DRB Application No.: 09DRB-70305 Project # 1007999
 Project Name: Freeway - Old Town
 Agent: BOHANNAN HUSTON INC. Phone No.:

DEVELOPMENT REVIEW BOARD--SPEED MEMO

DRB Comments

RE: Lot 2, Freeway – Old Town, Limited

PLAT OF  
**LOT 2-A & 2-B**  
**FREEWAY-OLD TOWN, LIMITED**  
(A REPLAT OF LOT 2 FREEWAY-OLD TOWN, LIMITED)  
ALBUQUERQUE, BERNALILLO COUNTY, NEW MEXICO  
SEPTEMBER, 2009

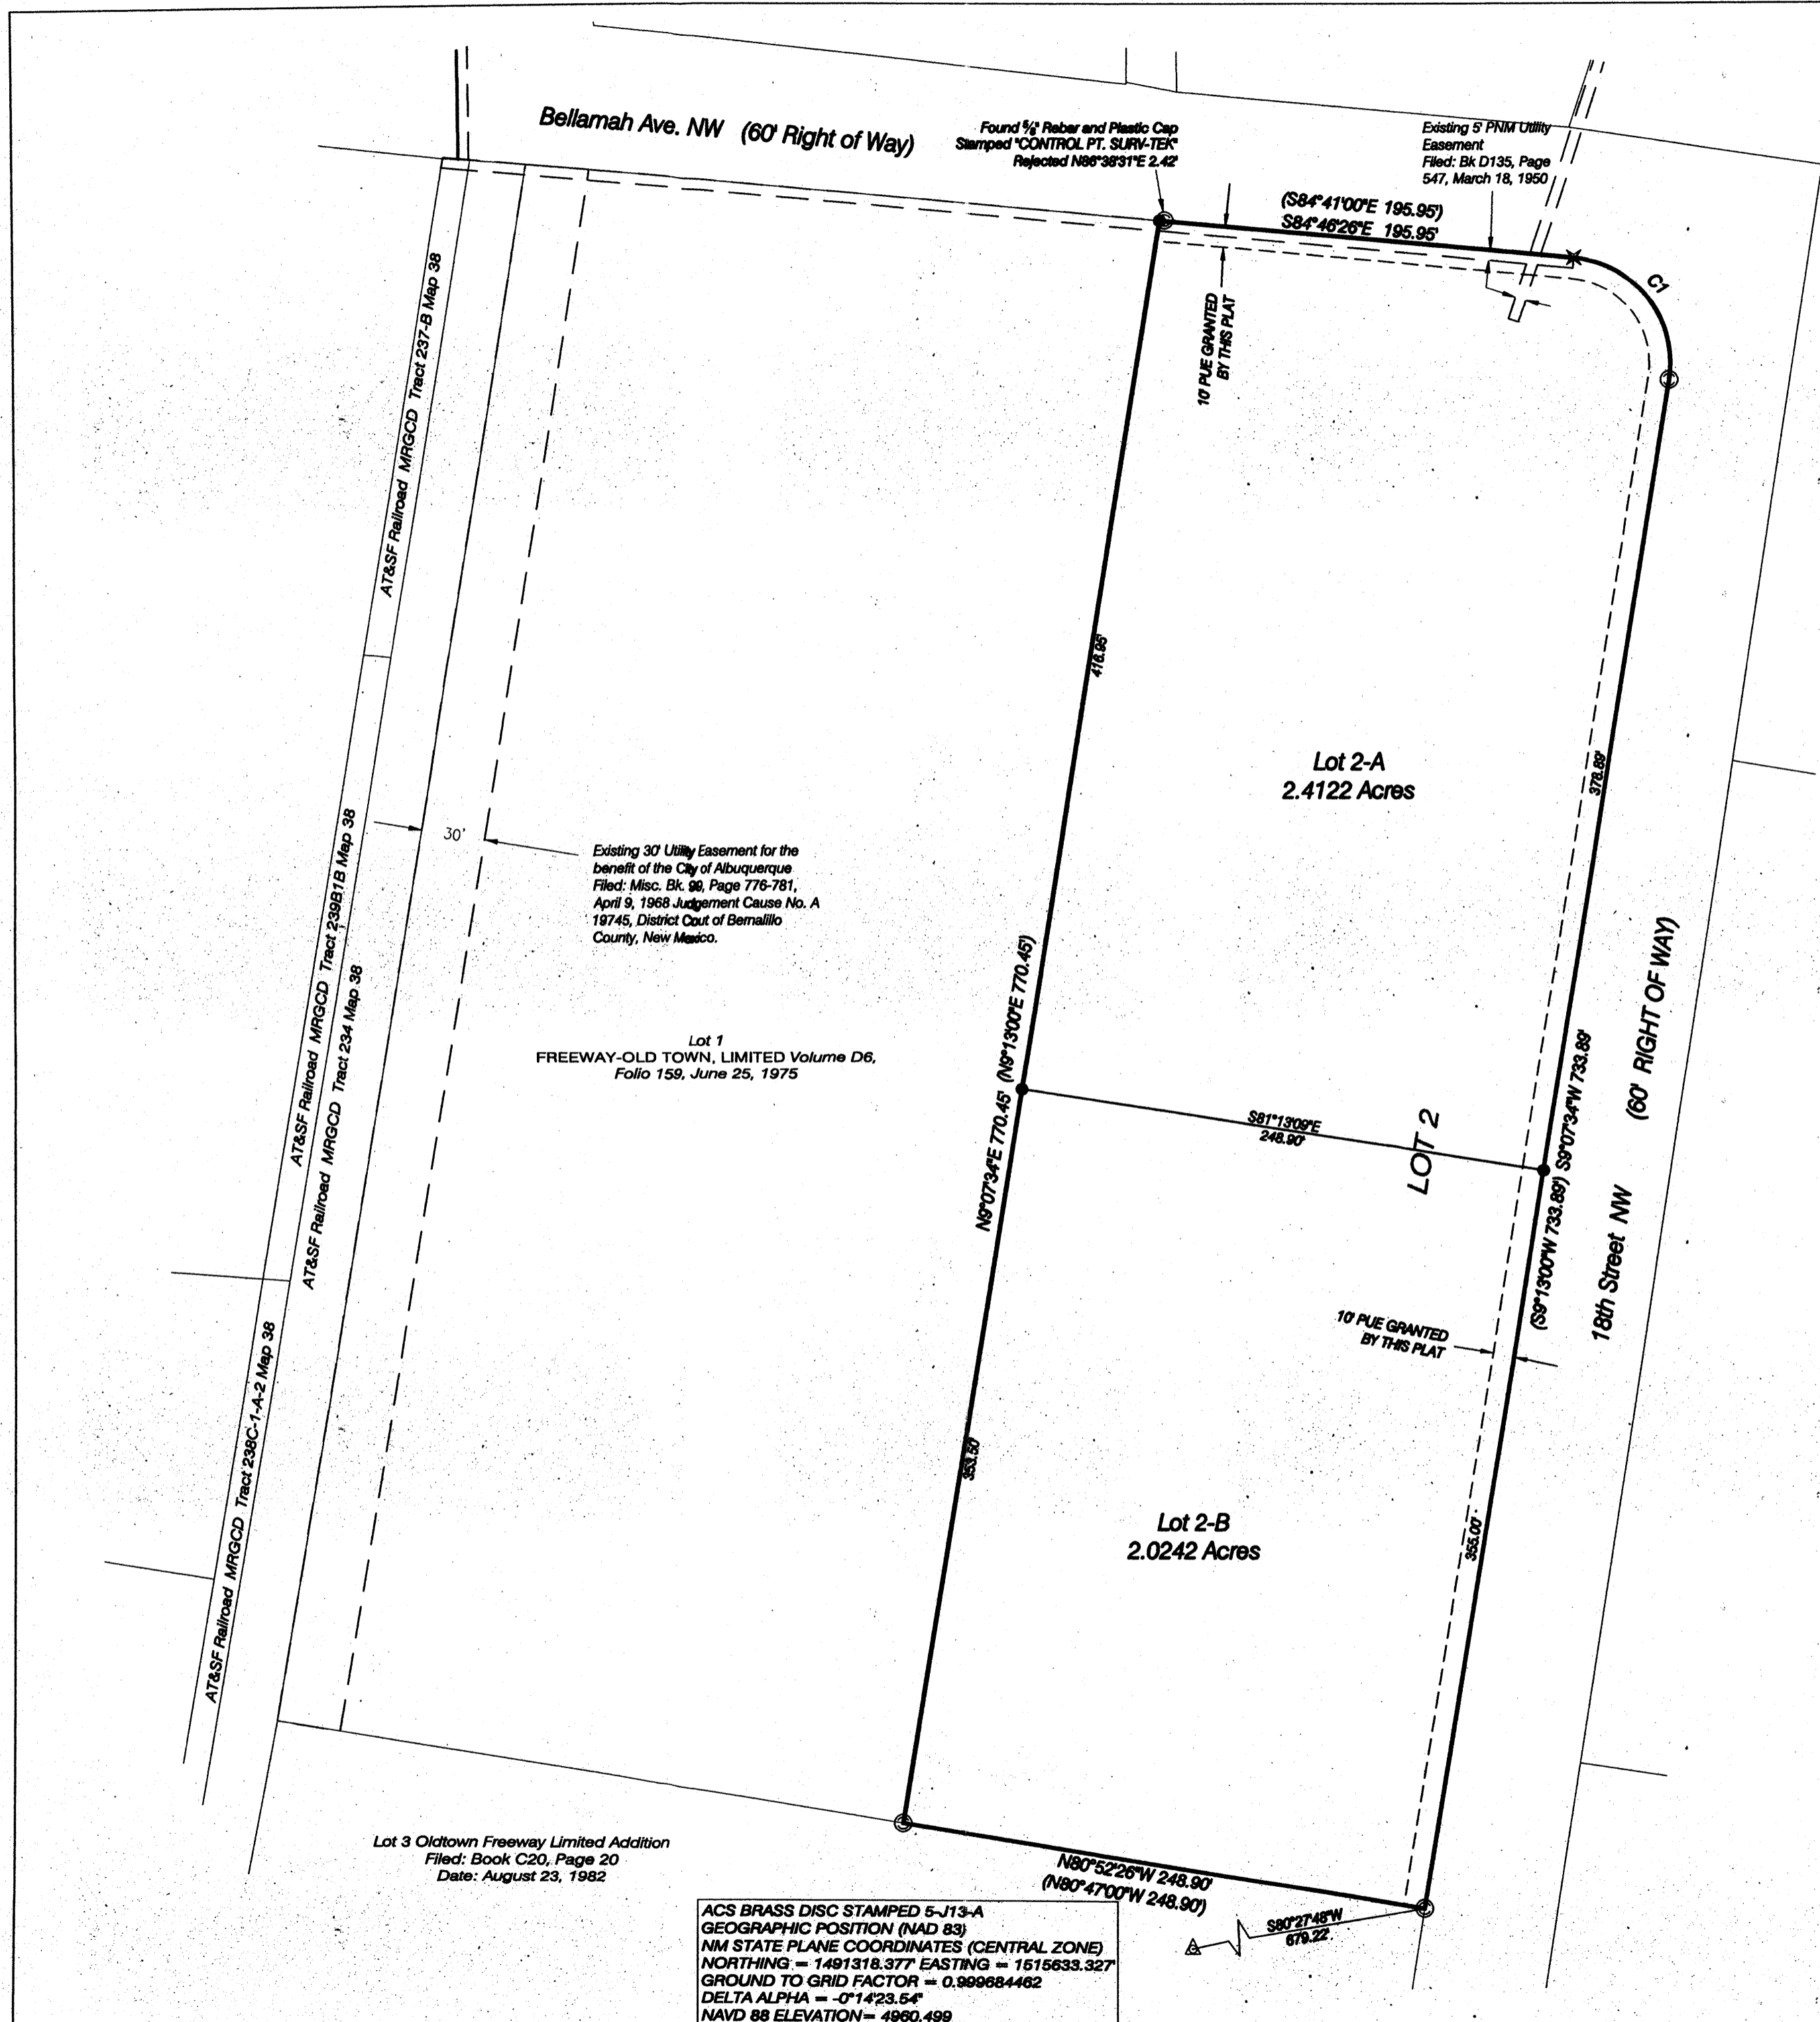
Need drainage easement with maintenance and beneficiaries stated.

Based on the exhibit provided, portions of the public sidewalk are located outside of the City Right of Way.
A public sidewalk easement or additional right of way dedication will be required.
A cross access easement is needed.

For future reference, please remove zoning note from final plat.

Reciprocal access and drainage easements are needed based on existing development.

It appears that a Public Sidewalk Easement (or Right of Way dedication) is also needed, at the street intersection – refer to comments from Transportation Development.
